PLANNING CONSULTATION RESPONSE

Application No	2026/0260
Proposal	2026 0260 Widening of Existing Access Point Dropped Kerb Driveway Part Demolition of Wall and Gate 540 Carlton Road Carlton
Address	540 Carlton Road Carlton
Date of Consultation Reply	090726
Consultee	Tony Wiles Senior Conservation Officer

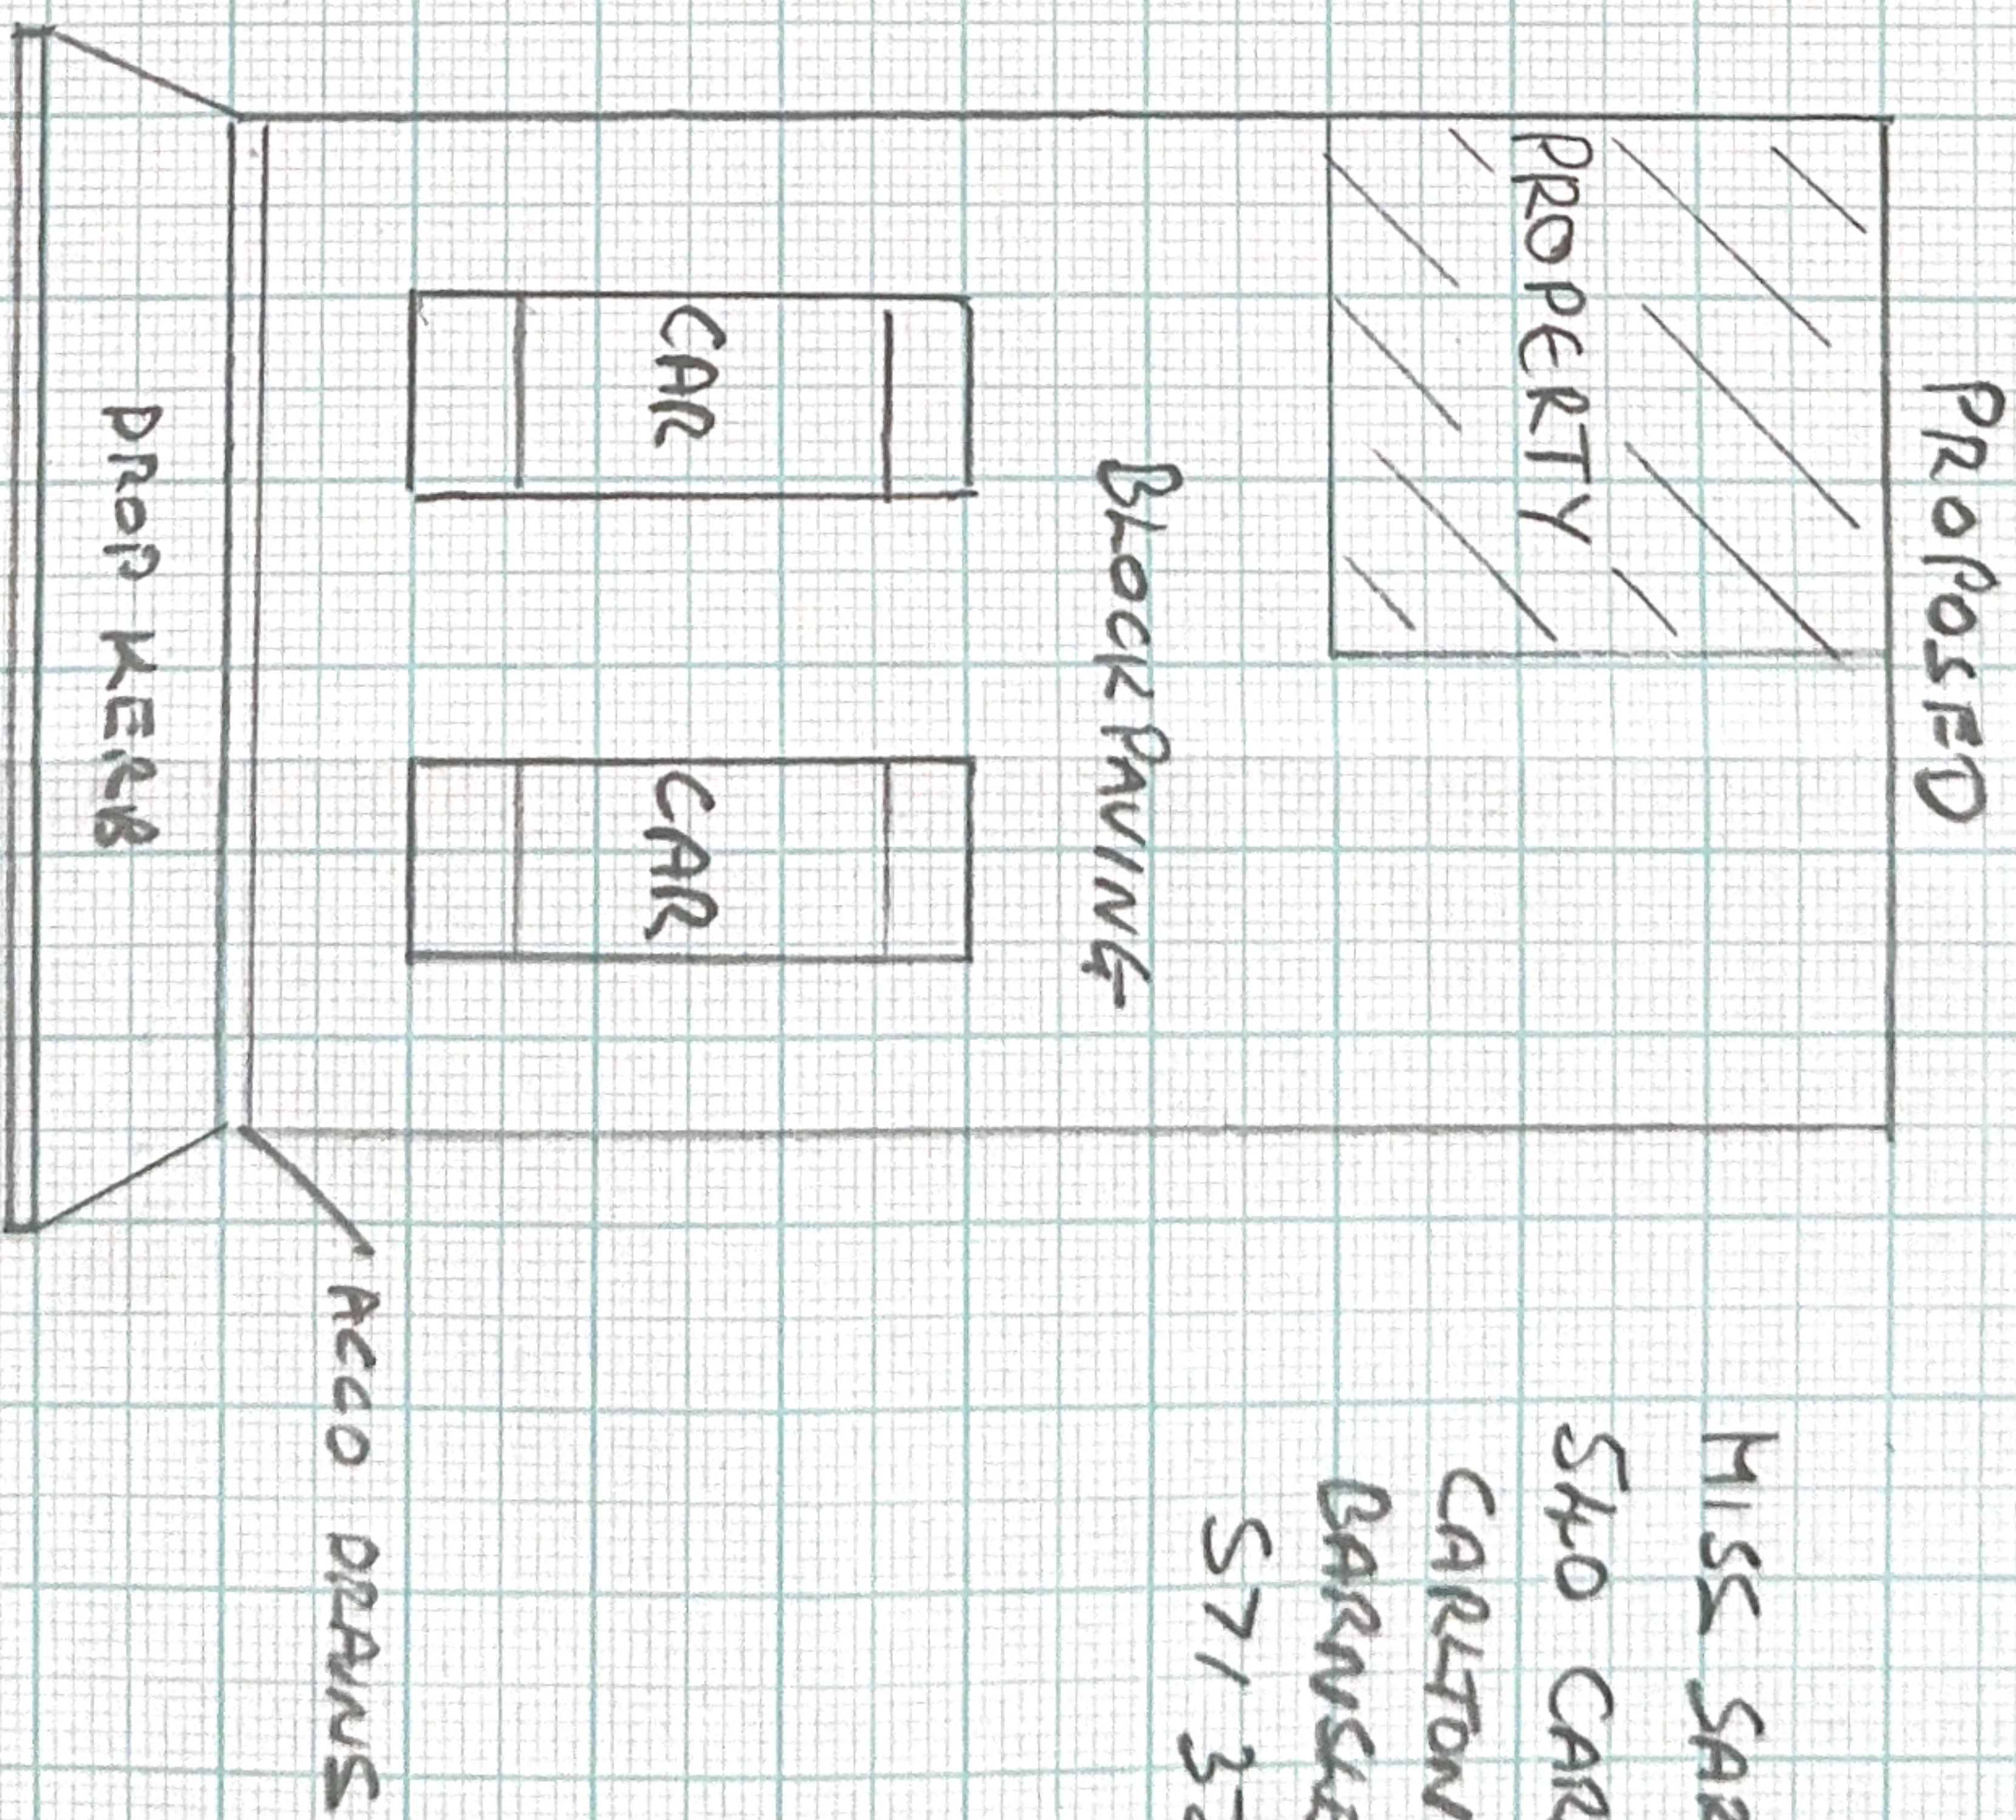
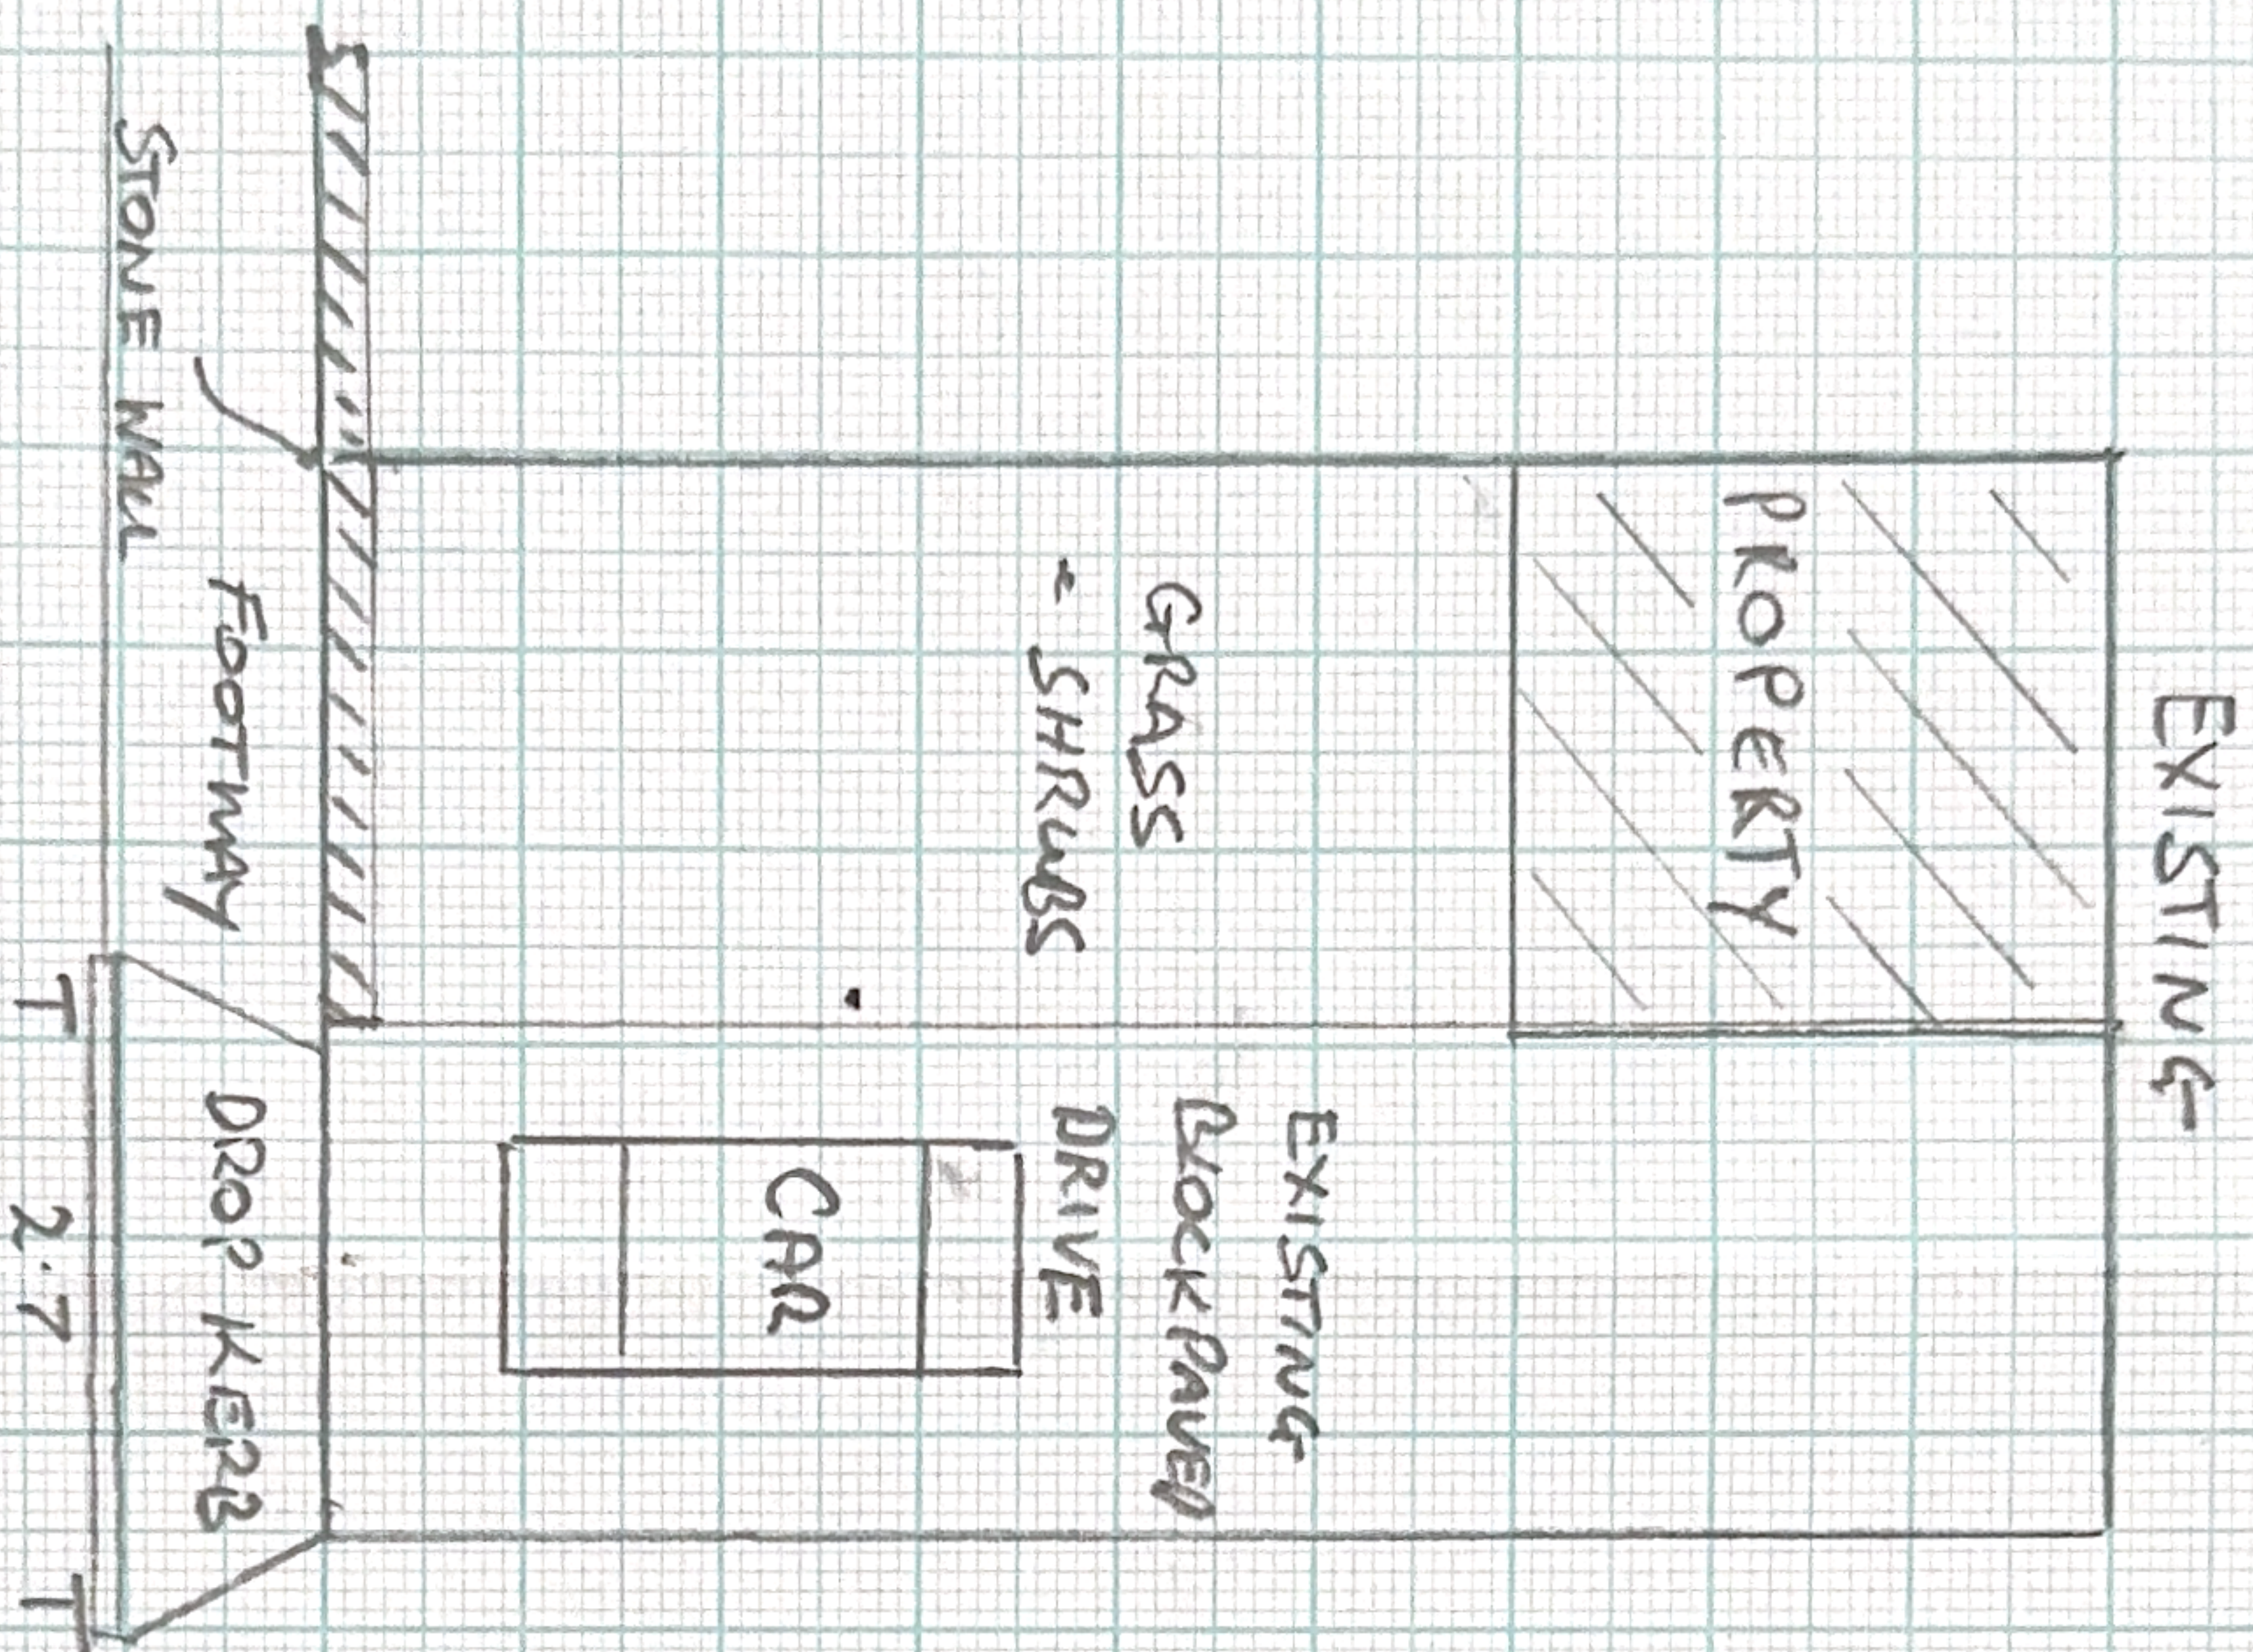
This application seeks permission to widen the existing access to No. 540 Carlton Road from the south, off Carlton Road. The driveway is currently served by a double-leaf set of gates and a single-width dropped kerb, approximately 2.7m wide. The remainder of the frontage comprises a stone wall of around 1.5m in height, backed by a mature hedge of approximately 2m. The property is a mid-C20, two-storey, double-fronted detached dwelling in brick, with a conservatory to the western elevation and a two-storey rear projection, with the house all under a Welsh slate roof. The site is vacant on the 1948 OS map but appears on the 1960 map; I would therefore estimate its date to be post-war, around 1950. The property lies within the conservation area and directly opposite St John's Church, which is listed at Grade II ([NHLE 1151146](#)). In terms of the contribution made by No. 540 to the conservation area and to the setting of the listed building, I consider this to be minor positive. Although clearly a later dwelling, its form, detailing, materials and layout help illustrate the post-war evolution of the Carlton townscape. The submitted plans are fairly rudimentary but appear to show the demolition of part of the wall and the widening of the existing gateway by a further 2.7m. The opening would be extended to the south-west to allow two cars to access a new block-paved driveway, creating an effective opening in the wall of approximately 5.4m. The wall, hedge

and garden area immediately south of the property would need to be removed to accommodate this change. In terms of the value of the wall and the effect on setting, I would note that:

- The wall is appreciably earlier than the present dwelling and is shown on the first edition 1850 six-inch Ordnance Survey map, fronting an earlier property, since demolished, which was orientated north–south.
- The wall is comparable and complementary to the churchyard wall to the south and reflects a historic boundary treatment found elsewhere within the conservation area.
- No. 540 appears to have been included within the conservation area boundary in part because of its proximity to No. 2 Royston Lane, the Old Post Office, and the much-altered Nos. 536 and 538 Carlton Road, fragments of which are shown on early maps.
- No. 540 has some minor positive group value within the conservation area.
- The loss of the garden area would introduce a more extensive area of hard landscaping to the frontage, within the setting of the listed building.

Taken together, I consider the proposal would result in a minor level of harm to the setting of the church and to the character and appearance of the wider conservation area. It could also risk setting an unhelpful precedent for further loss of historic boundary treatment elsewhere in the area. While the principle of some improvement to the access is not necessarily unjustified, an effective driveway opening of around 5.4m appears excessive given the age, character and contribution of the wall and its wider setting. I would therefore suggest that the proposal is amended to a more balanced arrangement, with a narrower but extended gateway that improves visibility while retaining more of the wall and better protecting the setting.
